**RE: Carlisle and Menaul Traffic Impact Study (H16D083F)**

Submittal Dated September 19, 2024

Bohannan Huston would like to thank you for reviewing and commenting on the submitted Carlisle and Menaul Traffic Impact Study, Record Number H16D083F. Please find the following responses from Bohannan Huston to the review comments dated December 10, 2024.

PROPOSED STREET SECTION			
CARLISLE AND MENAUL			
DRAWN BY:	JR	DATE:	01/22/2025
CHECKED BY:	KK	BHI PROJECT NO:	20240281
		SHEET NO.	---

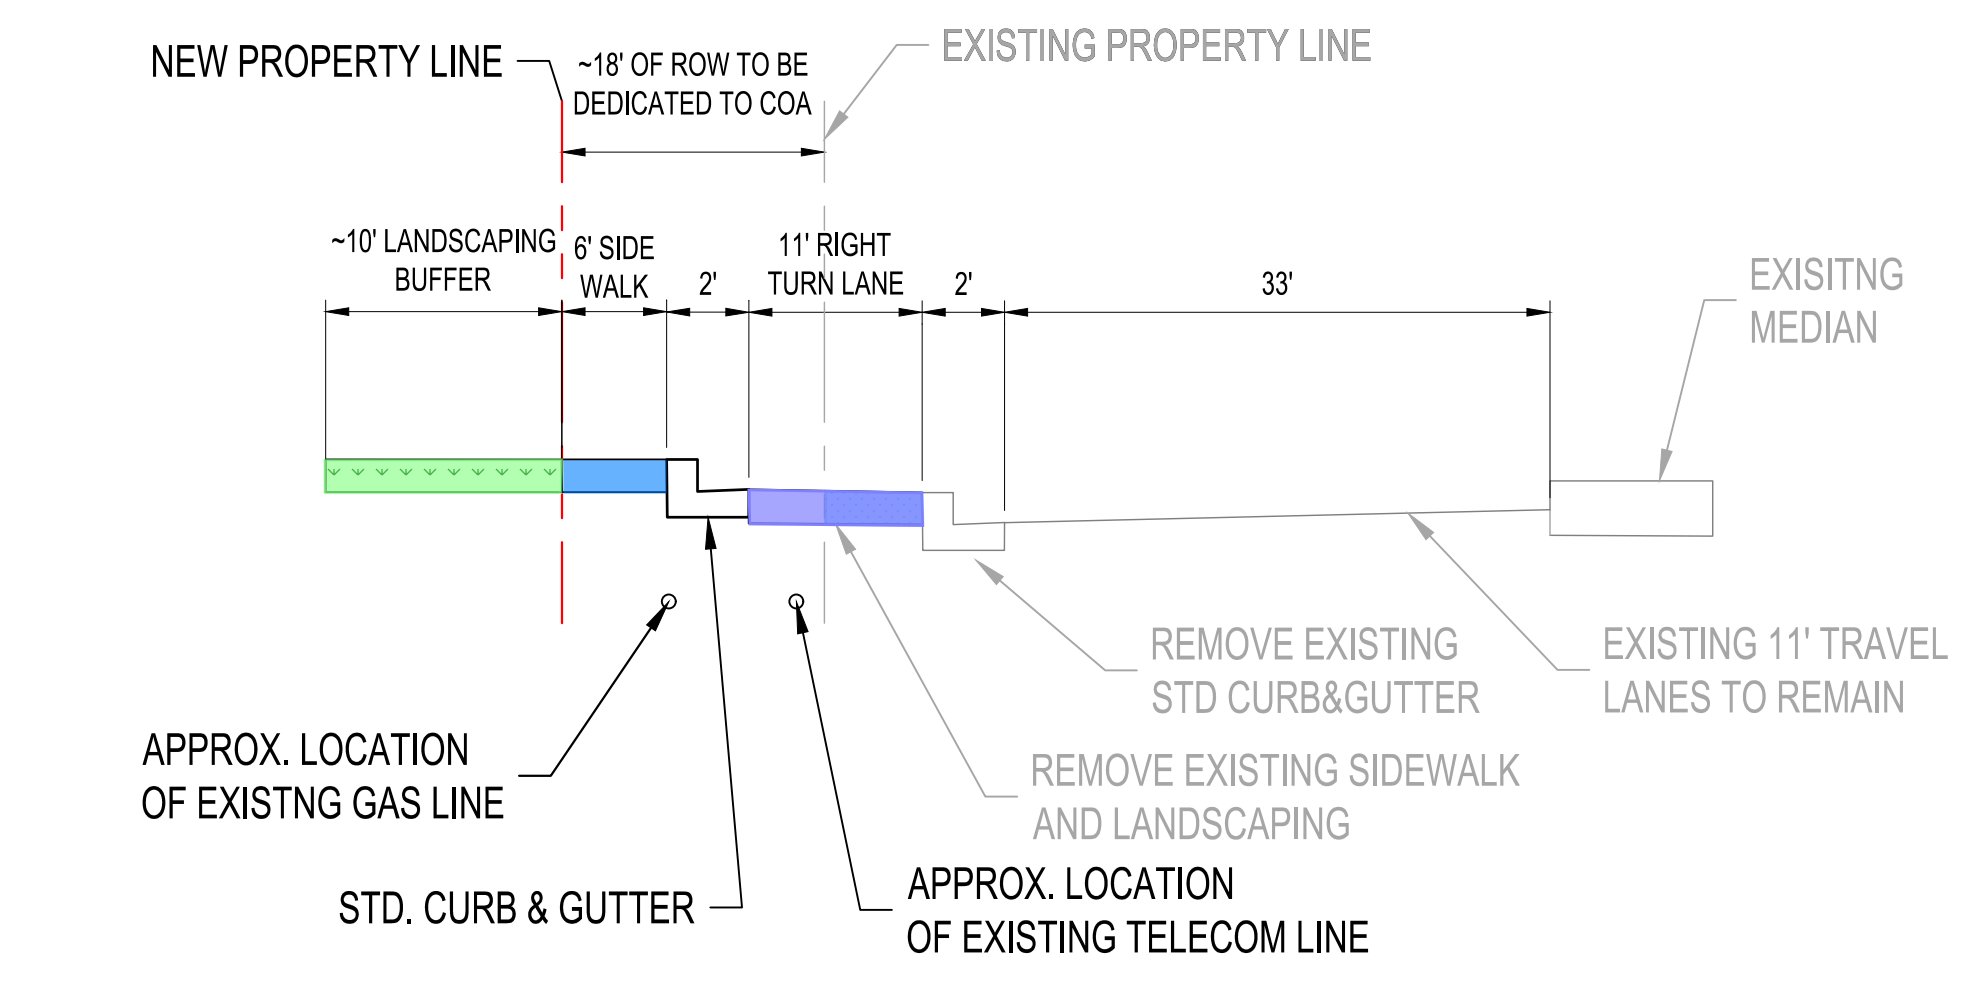
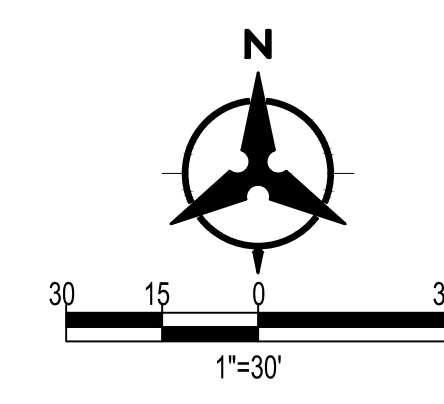
3. 2026 AM build volumes at Carlisle/Access 3 and Menaul/Access 2 appear to warrant a right-turn lane and may reduce crashes.

4. Agreed that Carlisle Blvd may benefit from a sidewalk buffer. It appears the site is being replatted, so incorporating a sidewalk buffer into the revised southbound Carlisle Blvd street section may not be an issue.

5. As part of revising the Carlisle Blvd southbound street section to accommodate the bike lane and deceleration lane, lane widths should be reviewed/proposed. Lane widths to be a maximum of 11' wide.

**Bohannan Huston Response:** Carlisle/Access 3 and Menaul/Access 2 do warrant a right-turn lane. This has been added into the report. The deceleration lane at Carlisle/Access 3 will allow

**a short 46' decel lane due to the space between the adjacent access point. The Menaul/Access 2 will require coordination with Transit to discuss the existing bus stop located in this area.**

**Bohannan Huston Response: We are requesting a variance to keep the existing current existing sidewalk location with no buffer. We are requesting this to keep continuity with existing infrastructure north and south of the site. If we were to add this buffer space in, the crossing distances across the access points will increase that may effect pedestrian safety in the area.**

**Bohannan Huston Response: The deceleration lane at Carlisle/Access 3 is warranted and has been updated in the TIA. Due to the adjacent access point, a maximum of 46' will be allowed at this location for the deceleration lane.**

CARLISLE AND MENAUL			
DRAWN BY:	JR	DATE:	01/06/2025
CHECKED BY:	KK	BHI PROJECT NO:	20240281
		SHEET NO.	---

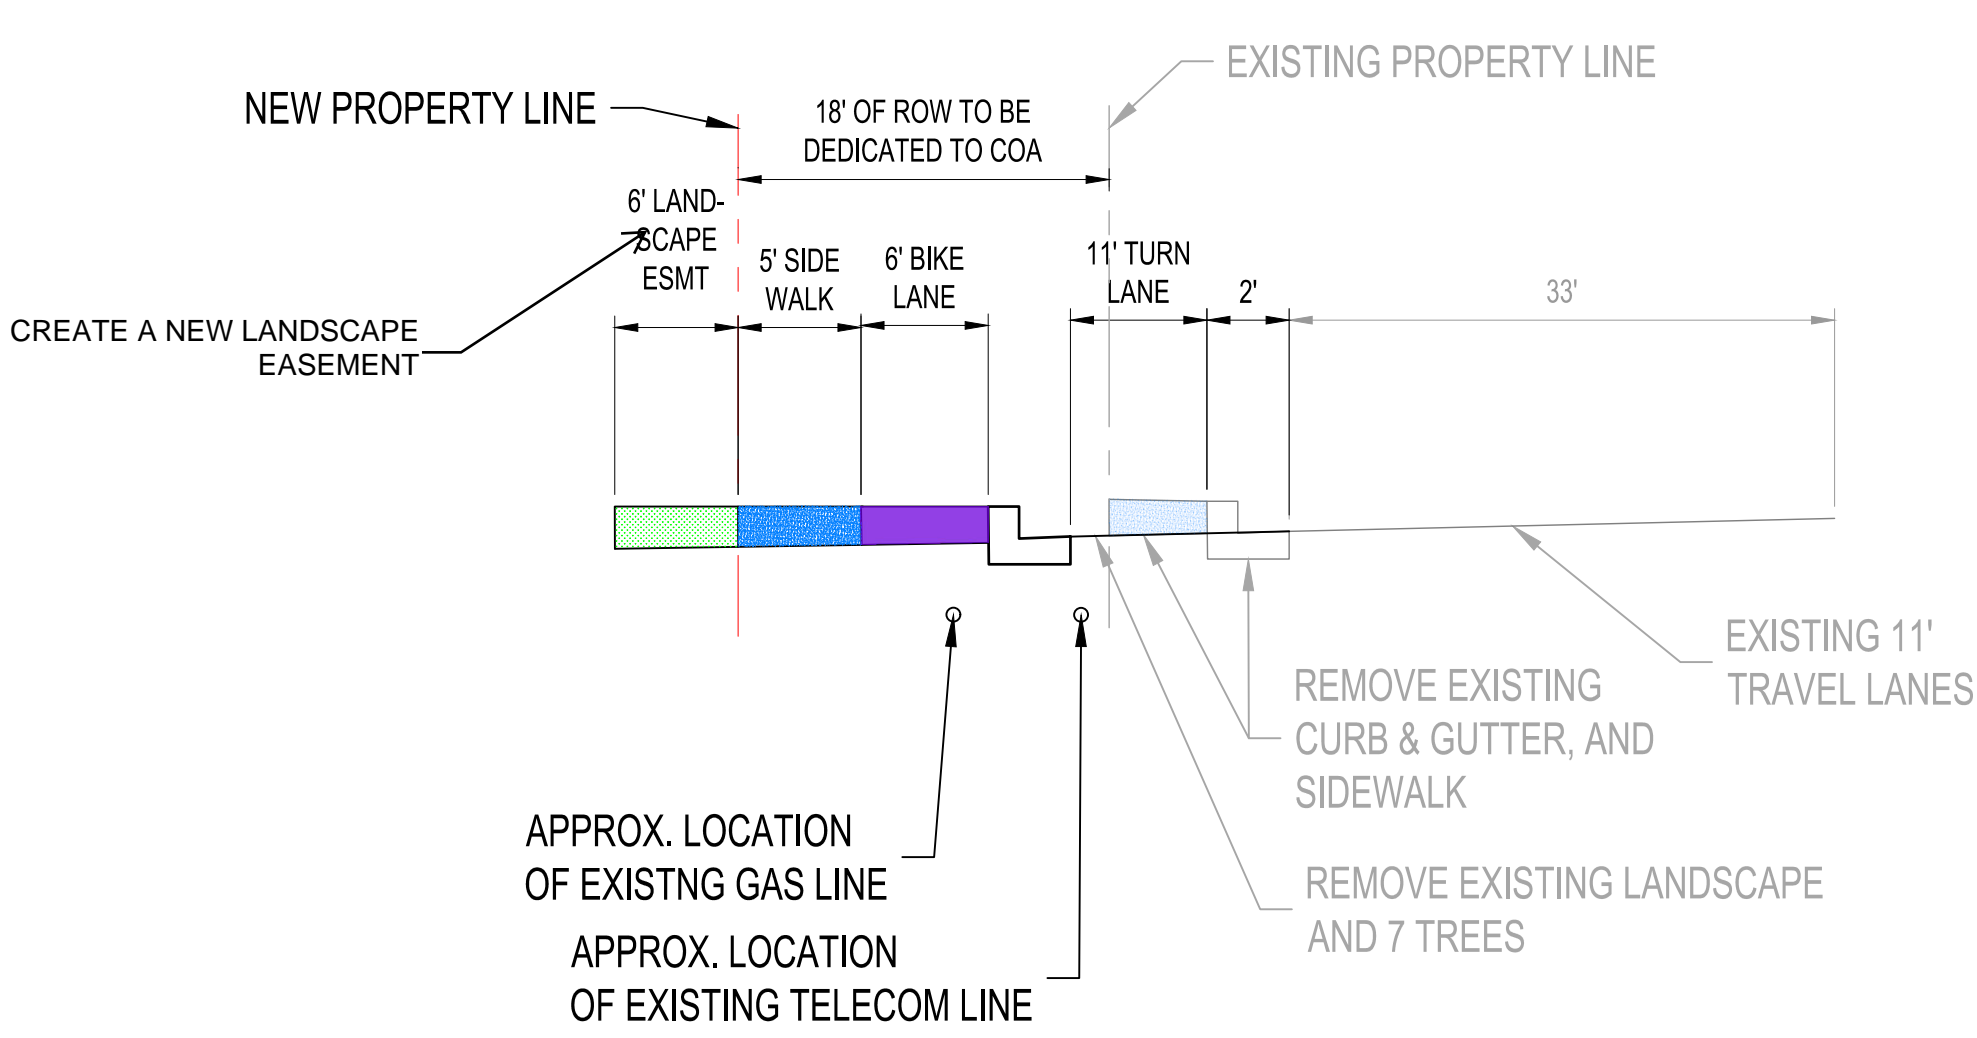
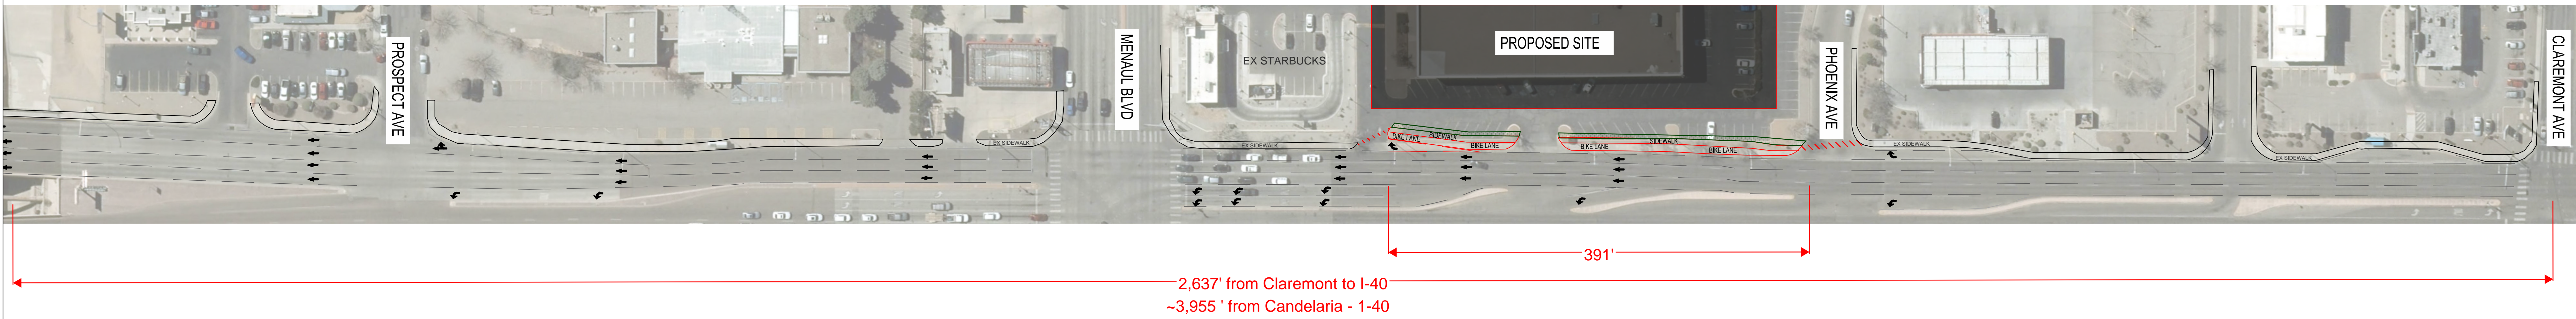
2. In agreement with the Study that bicycle crashes in this area may be decreased by the installation of bicycle infrastructure, NMDOT comments, MRCOG's Long Range Bikeway System and bike lane Improvements/pending improvements on Carlisle Blvd south of I40, the project is to construct a 6' wide bike lane with a 2' buffer along its Carlisle Blvd frontage.

**Bohannan Huston Response:** This request included updated information from the MRCOG's Long Range Bikeway System and follow up email from Curtis on January 17, 2025 rescinded this comment
